January 9, 2024

**Re: Sage Plaza Storage
Erosion and Sediment Control Plan
Engineer's Stamp Date 1/4/24 (M09E012B)**

Based upon the information provided in your submittal received 1/5/2024, the above-referenced ESC Plan cannot be approved for Grading Permit or Building Permit until the following comments are addressed.

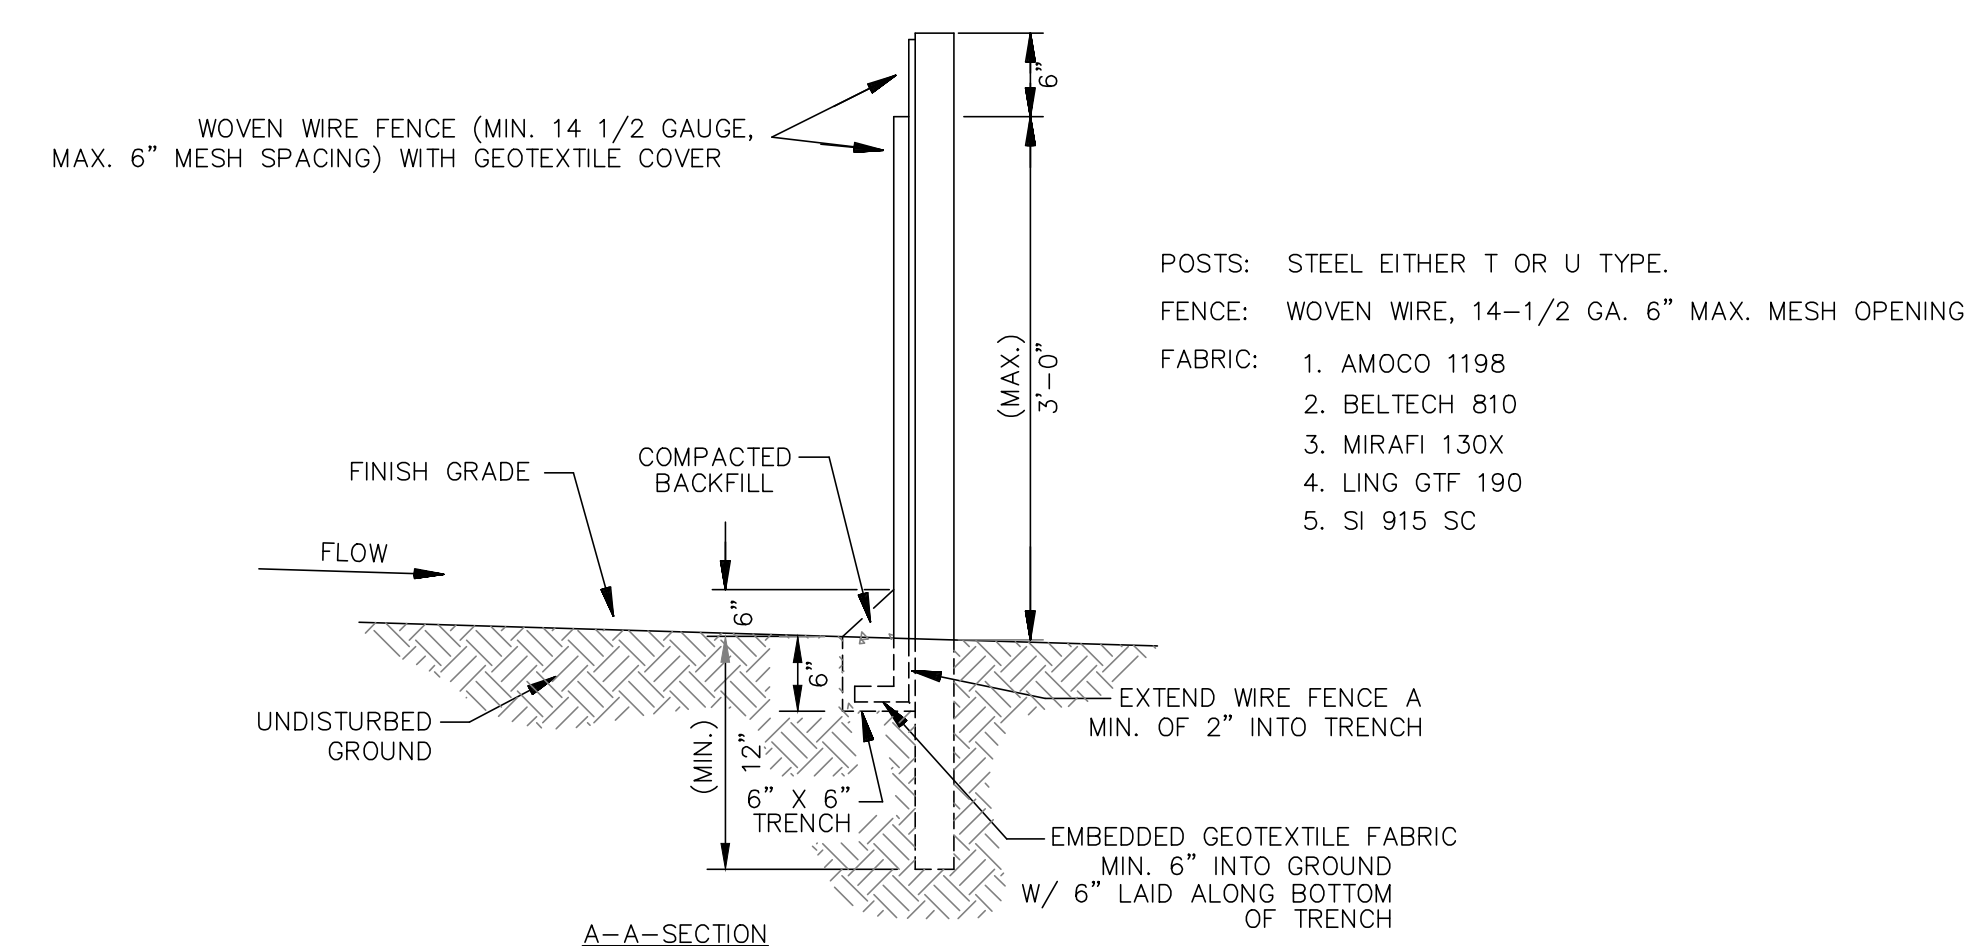
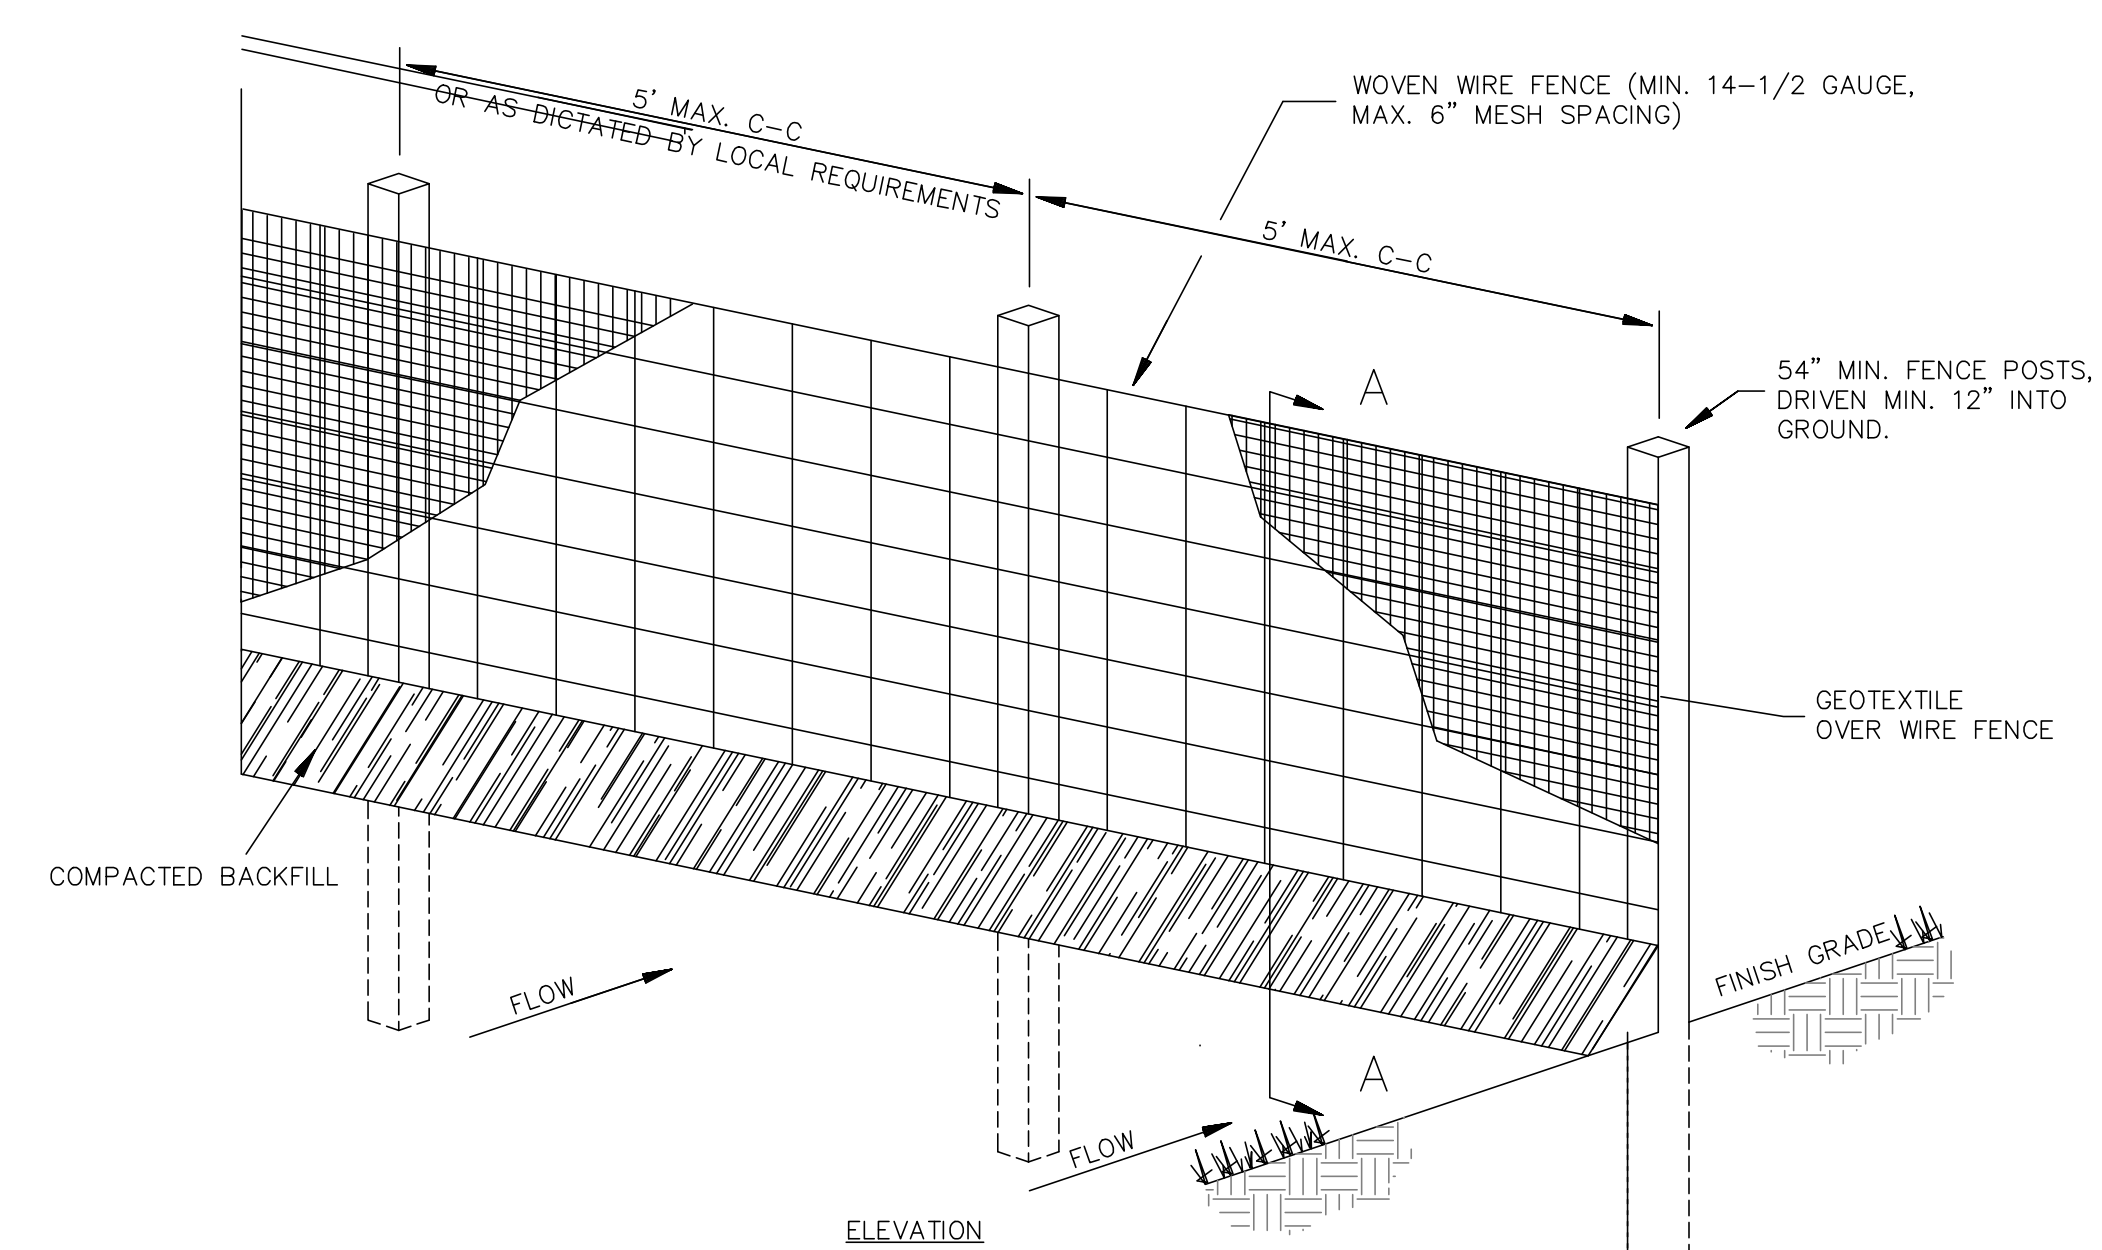
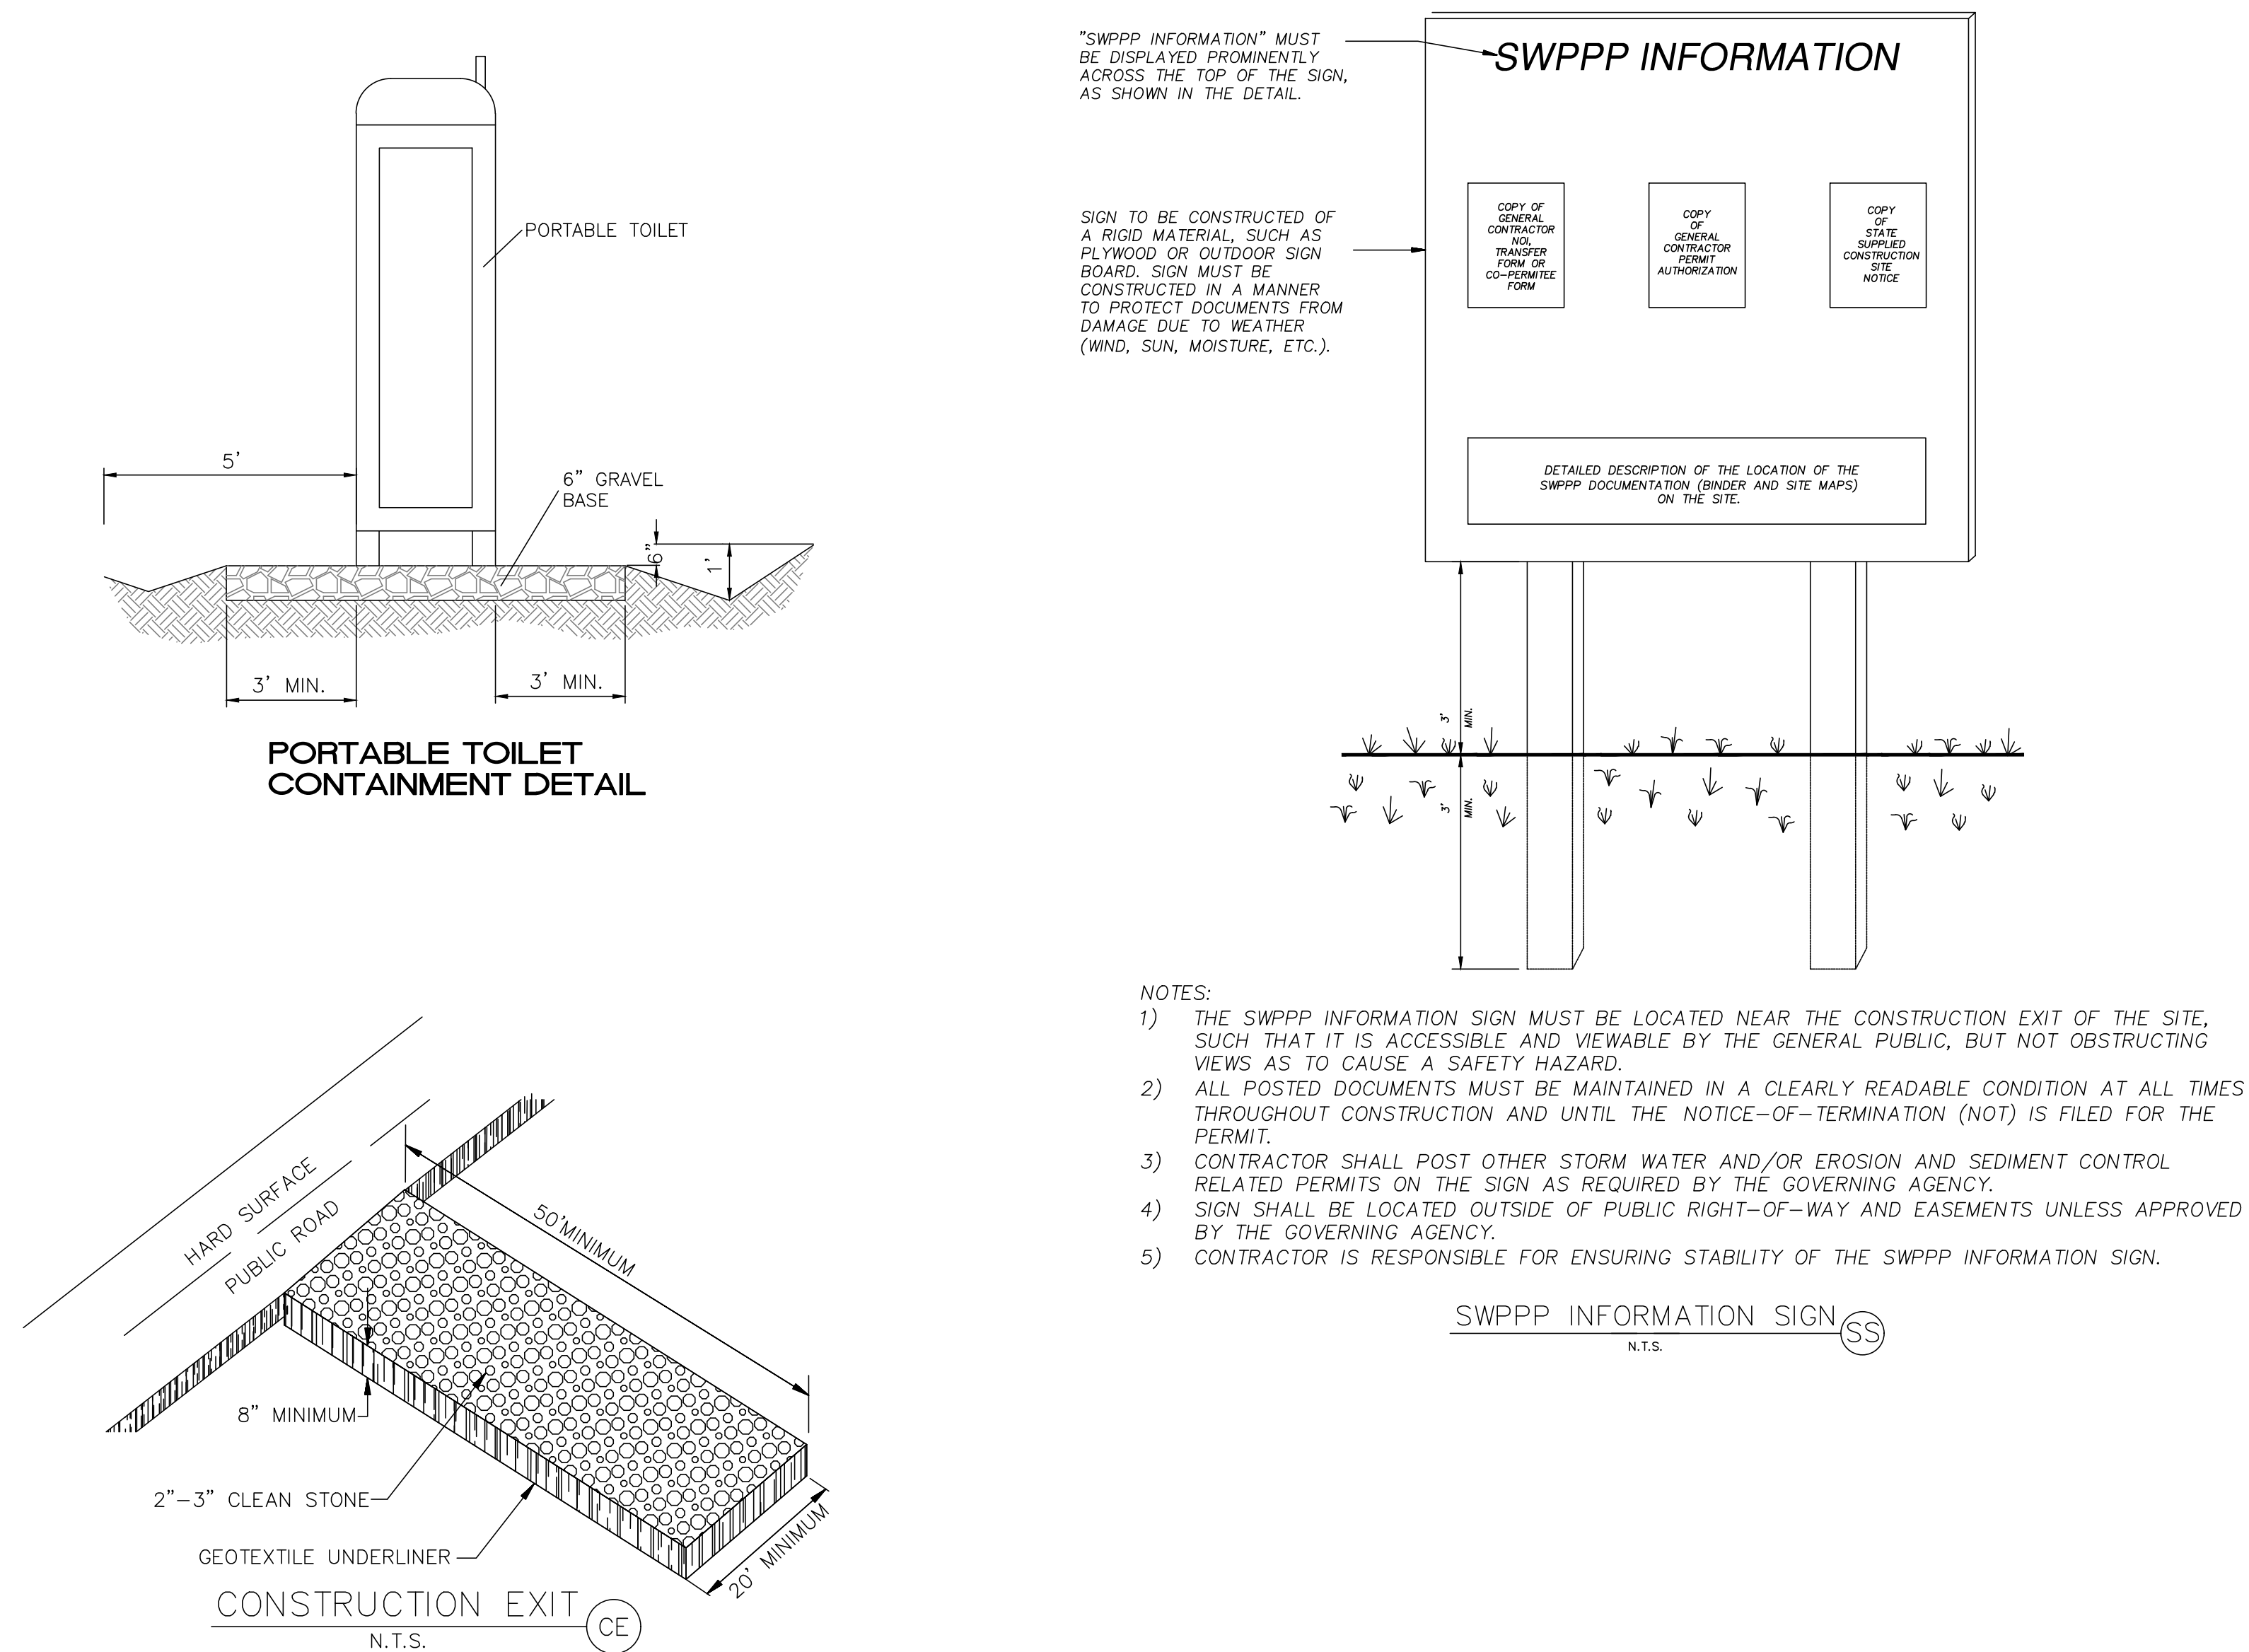
5. Provide calculations for the Sediment Trap design showing compliance with CGP Part 2.2.12.c which requires storage for either:
 - a. The calculated volume of runoff from a 2-year, 24-hour storm; or

- b. 3,600 cubic feet per acre drained.
